Bioregional's response to 'Proposed Himley Village, North West Bicester, Middleton Stoney Road, Bicester, Oxfordshire (no: 14/02121/OUT)

This report outlines Bioregional's key observations on the Himley Village outline application (14/02121/OUT). We have reviewed the application documents against the overall Eco Town aspirations, the PPS1 Supplement on Eco Towns and the Bicester One Shared Vision.

Indicative plan - Existing Hedgerows

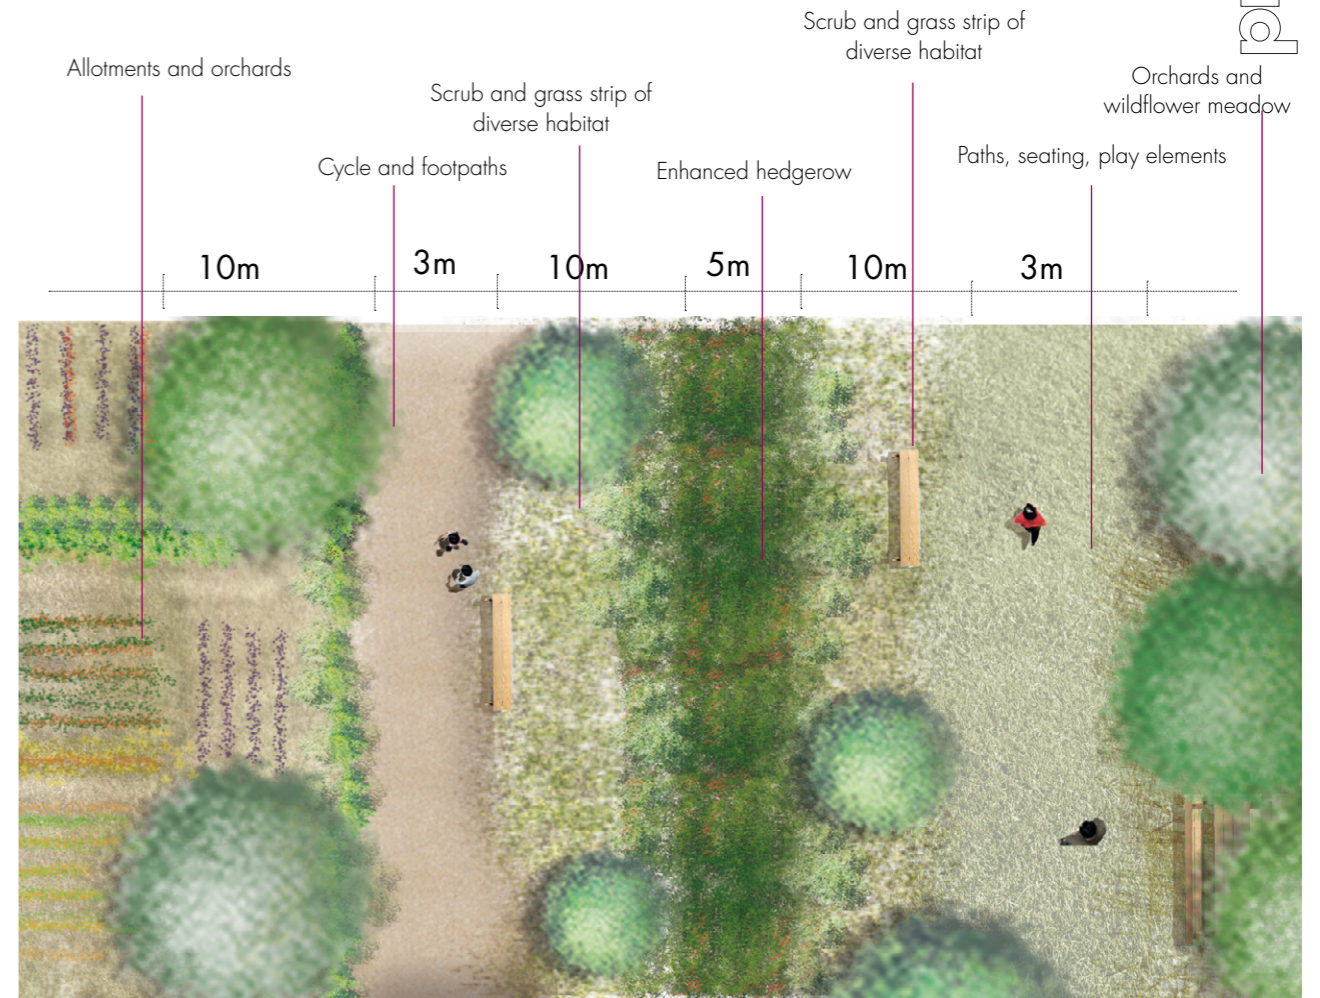
There is a commitment on page 109 of the Design and Access Statement that existing hedgerows will be enhanced with a 10m wide buffer. However, we could not find detail of the creation and protection of dark corridors. The NW Bicester Masterplan GI and Landscape Strategy (pages 40 - 41) have detailed commitments regarding dark corridors and the 20m buffer either side of the hedgerow. As part of the NW Bicester Masterplan, we would expect this application to follow these commitments.

We would welcome the inclusion of a 'hedgerow removal and break' map to understand the amount of hedgerow to be removed and how this will be mitigated. In particular, can these breaks be minimised by narrowing and arches and will hedgerow loss be compensated by translocation or new planting?

Drawing Title
Landscape - Parameter Plan 3

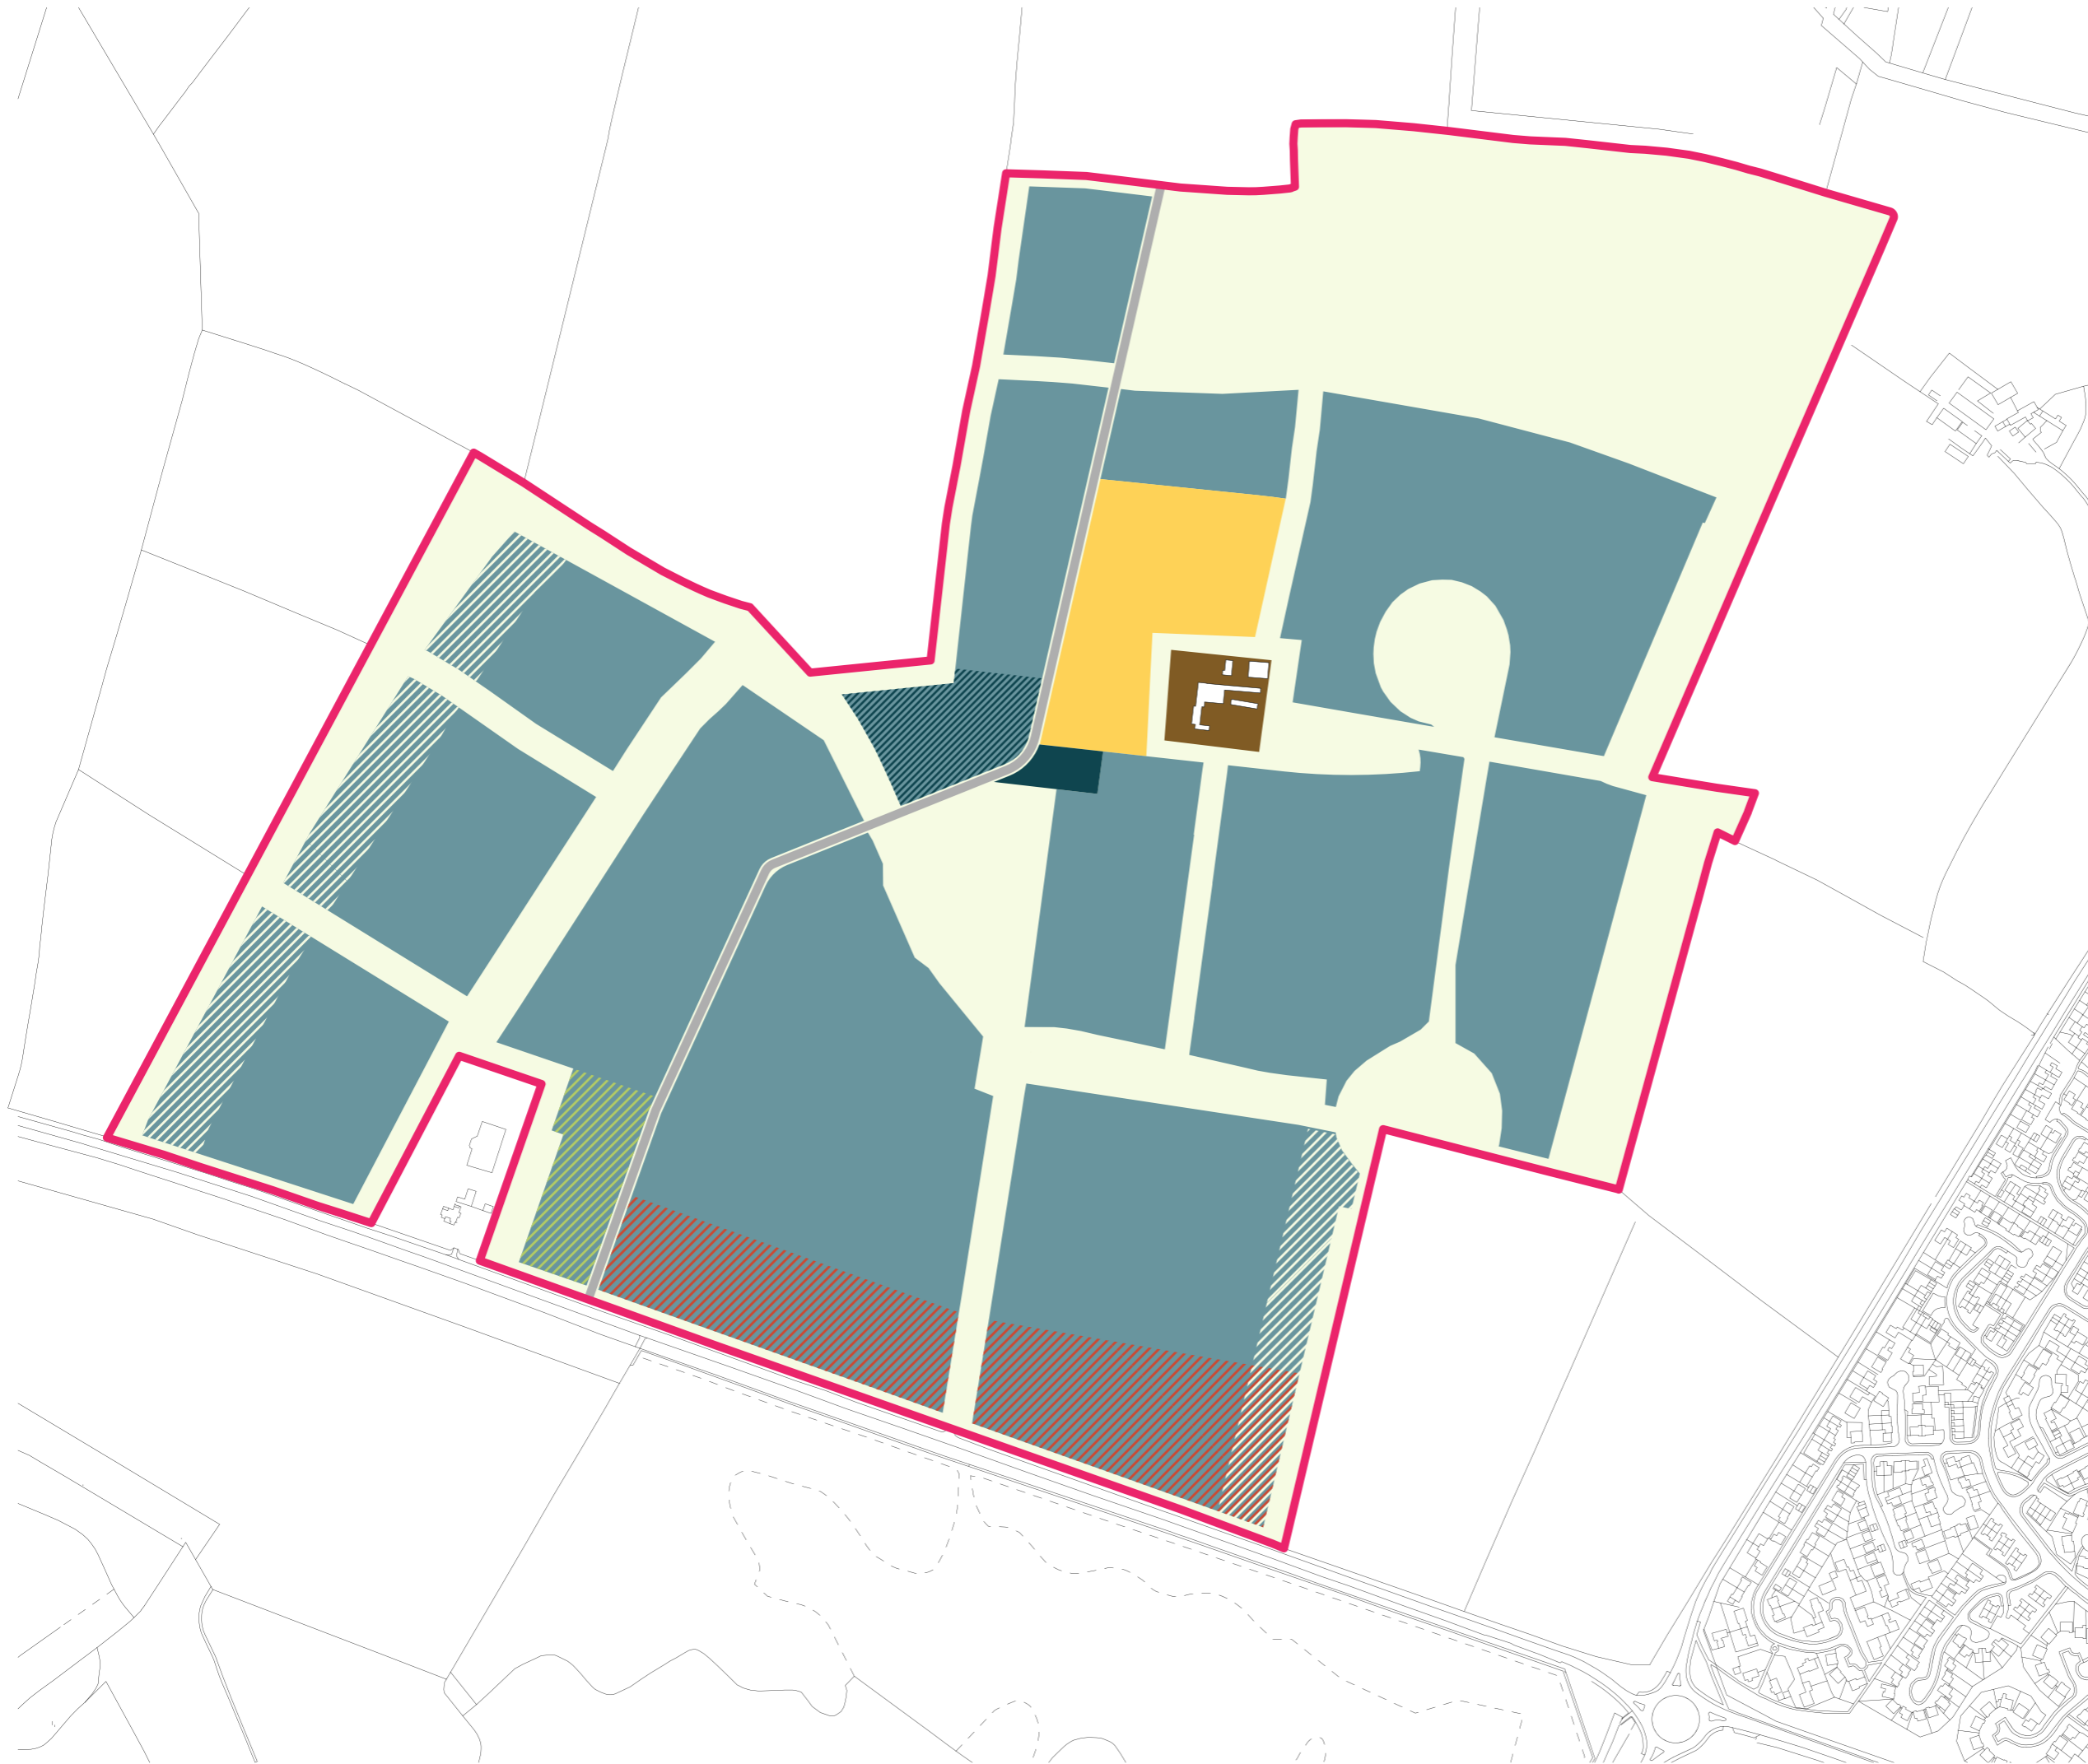
The Design and Access statement refers to a commitment to achieve 40% GI across the development area (as defined by PPS ET14); however, the application does not include a land use schedule that would confirm how this is achieved.

8. Full land use schedule to understand the mix of green spaces and compliance with the 40% GI standard
9. A discussion around the principles of how green space is used on the front and back of homes
